## **LINCOLNSHIRE COUNTY COUNCIL'S RESPONSE TO CONSULTATION ON THE FOLLOWING DEVELOPMENT PROPOSAL**

**Application number: H13-0261-25**

**Proposal: Erection of detached two storey dwelling, annexe & garage**

**Location: Land off Fen Gate, Moulton Chapel, Spalding, Lincolnshire, PE12 0QA**

PROPOSED SITE LAYOUT
SCALE 1:200

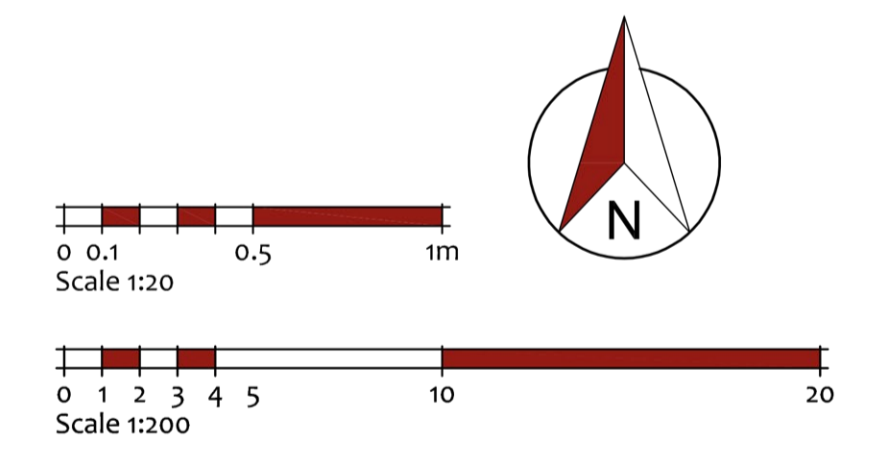
The proposal is for Erection of detached two storey dwelling, annexe & garage and it does not have an impact on the Public Highway. There will be a requirement to provide a new vehicular access off Fengate. Suitable visibility can be provided at the access including sufficient parking and turning facility within the development site to allow vehicles to enter and leave in a forward gear so drivers are able to judge if it is safe to complete the manoeuvre and enter the highway and therefore, it is considered that this proposal would not result in an unacceptable impact upon highway safety.

There will be a requirement to extend the existing 30mph speed limit further North of the development site and provide a frontage footway from the development site in a Westerly direction making connection with the existing footway network for safe and suitable pedestrian connectivity.

The development hereby permitted shall not be occupied before a 2.0-metre-wide footway, to connect the development to the existing footway network, has been provided in accordance with details that shall first have been submitted to, and approved in writing by, the Local Planning Authority. The works shall also include appropriate arrangements for the management of surface water run-off from the highway.
